CITY OF ALBUQUERQUE

September 28, 2016

Re: TMobile Retail Building
2706 Carlisle Blvd NE
Traffic Circulation Layout
Engineer's date 09-15-16 (H16-D148)

PROJECT TITLE  2706 CARLISLE BLVD. NE ALBUQUERQUE, NEW MEXICO 87110		JOB NO. 2016013		DRAWN BY: JEFF WOOTEN	
PROJECT MANAGER JEFF WOOTEN		SHEET TITLE Engineering Site Plan			
DATE: 9/2/2016		sheet: C1.1			
SCALE: AS NOTED		of 3

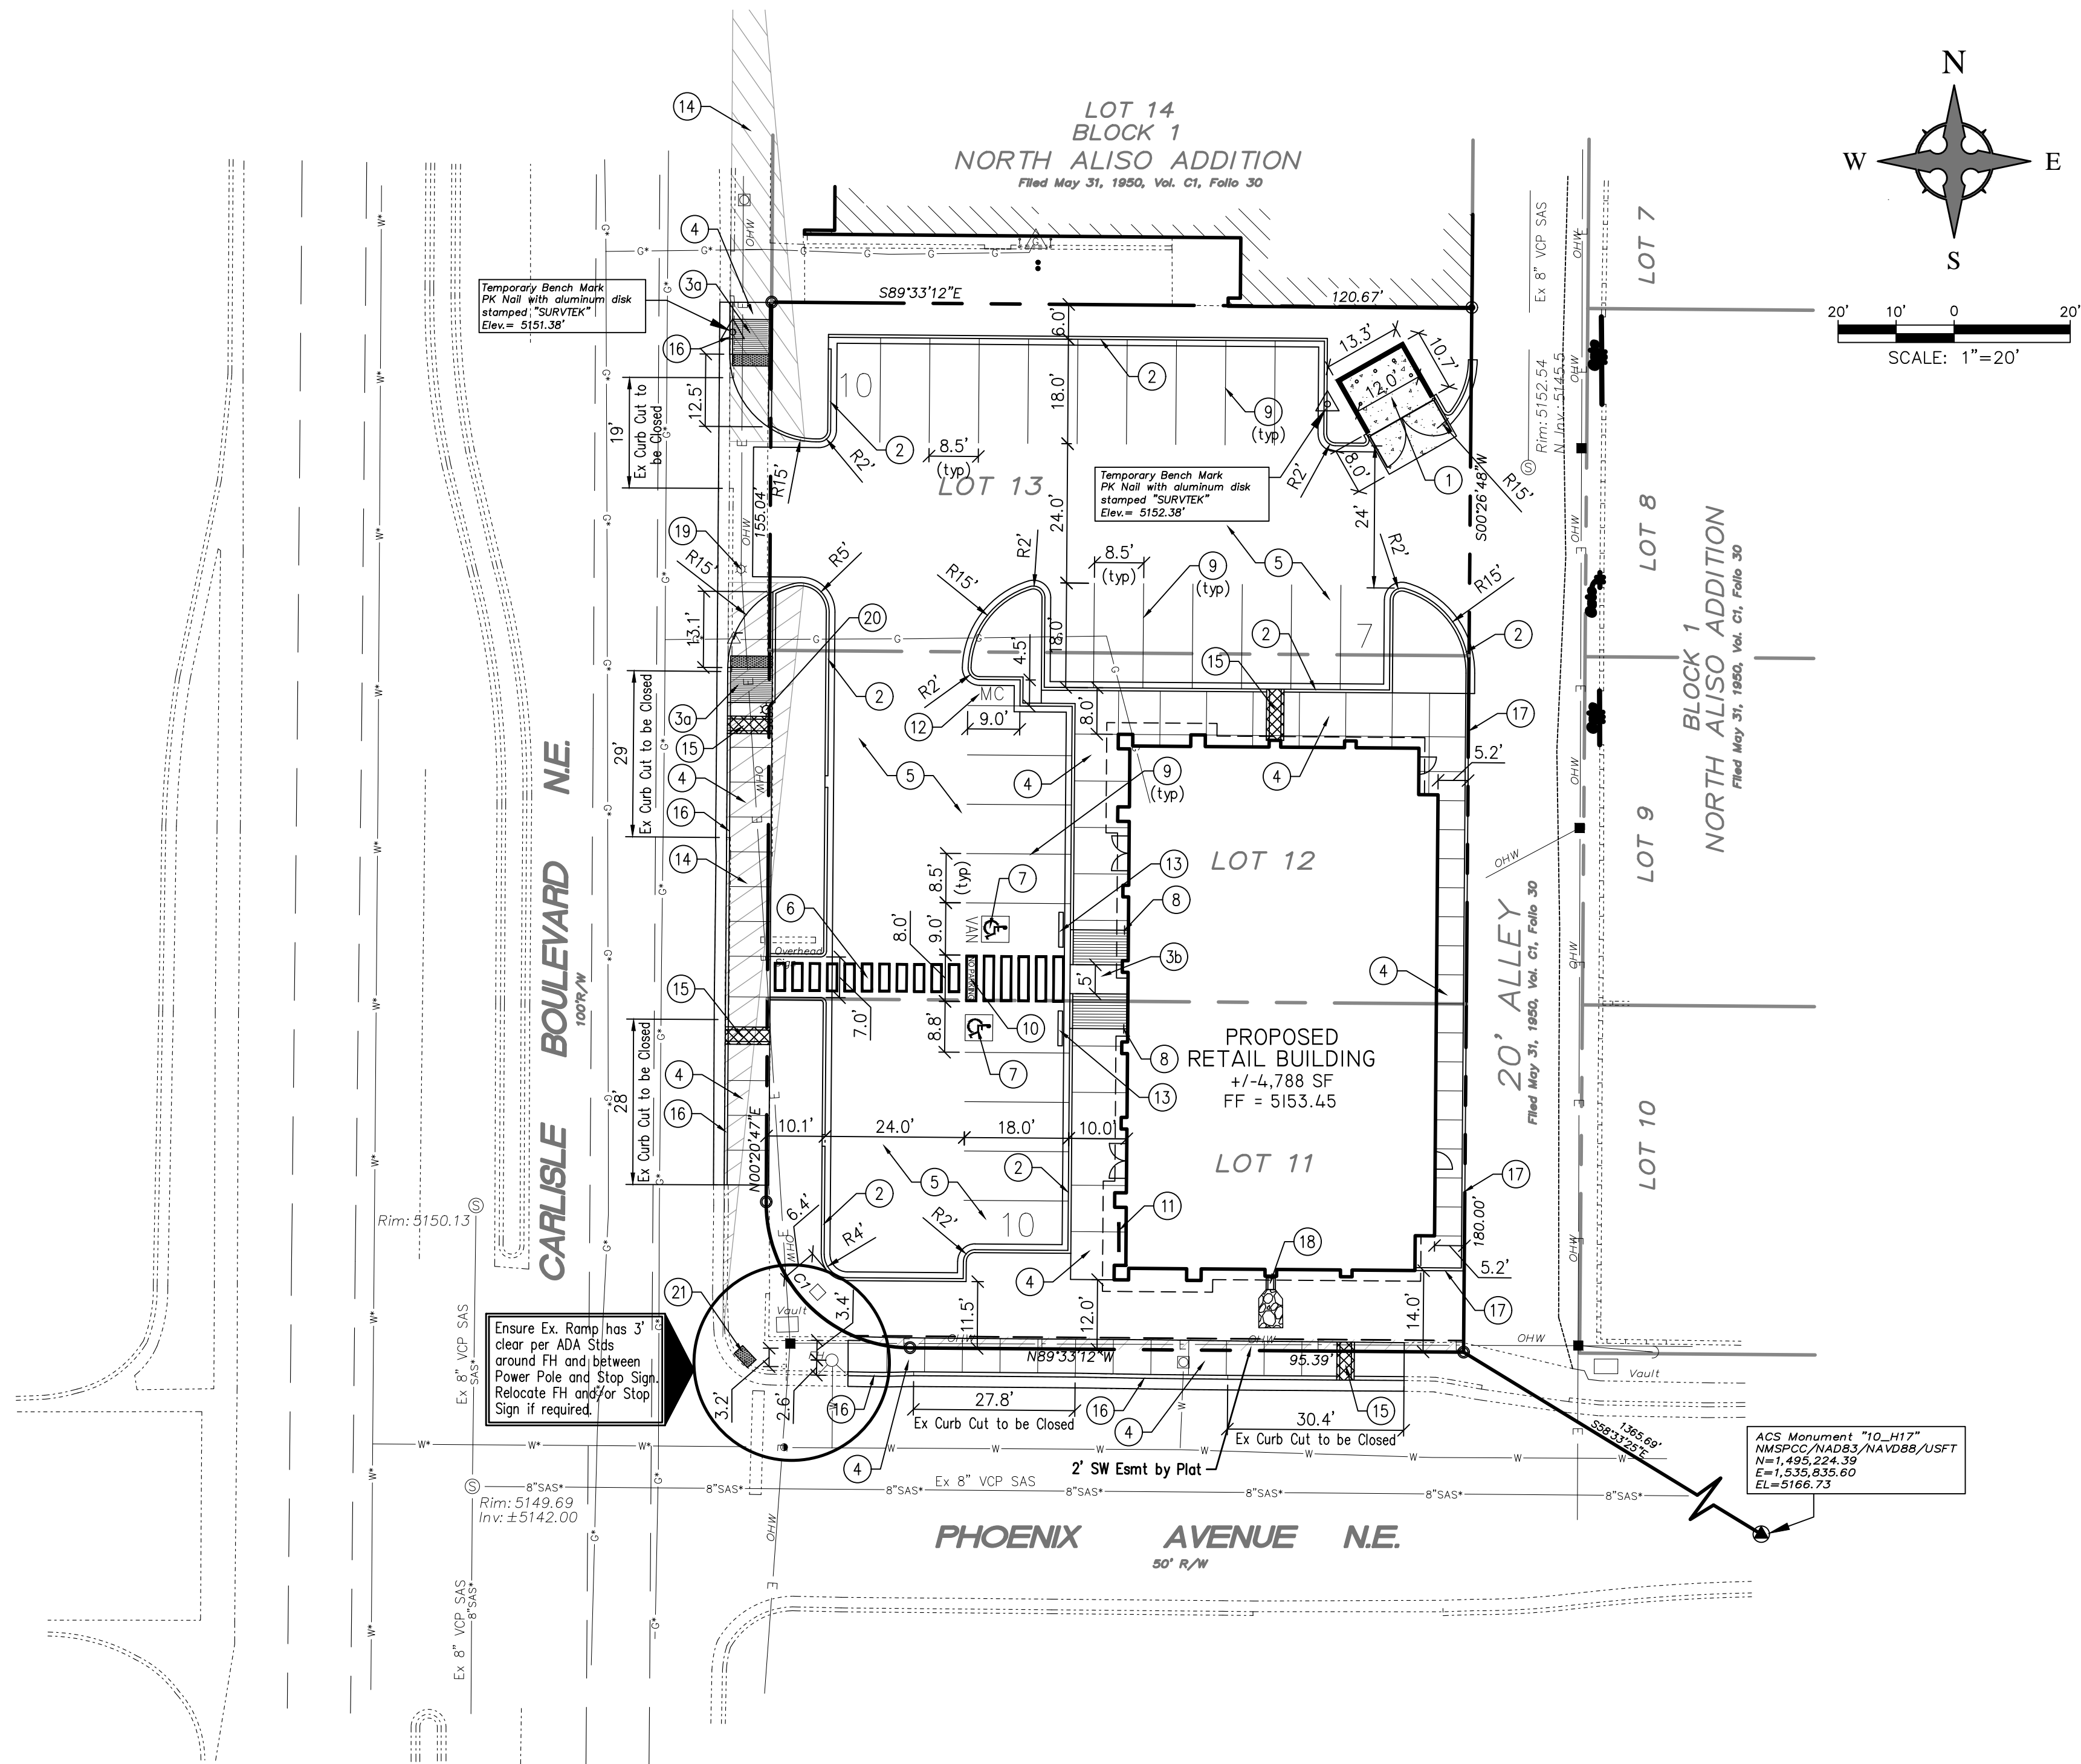
1. Please identify all existing drive pads and anything that influences the parking and circulation on the site. In particular the two drive pads on Phoenix and the light pole on Carlisle.

2. All sidewalks along streets should be placed at the property line. The sidewalk along Phoenix will require a sidewalk easement if it crosses the property line.

3. Please provide dimensions for the ADA wheelchair ramp on the corner of Phoenix and Carlisle and location of the power pole and fire hydrant at ramp. The ramp will require installation of a cast in place Detectable Warning Surface and will need to be replaced if it does not conform to ADA standards.

4. Please dimension on all ADA pathways. Connection from the sidewalk to the front should be 6 feet wide. Also use NMDOT ADA specifications 608-001 for Detectable Warning Surface detail and location, found at [http://dot.state.nm.us/content/dam/nmdot/Plans_Specs_Estimates/Standard Drawings/608.pdf](http://dot.state.nm.us/content/dam/nmdot/Plans_Specs_Estimates/Standard_Drawings/608.pdf). Add note for DWS "Cast in place replaceable".

5. Sidewalk culvert will require a SO19 permit.
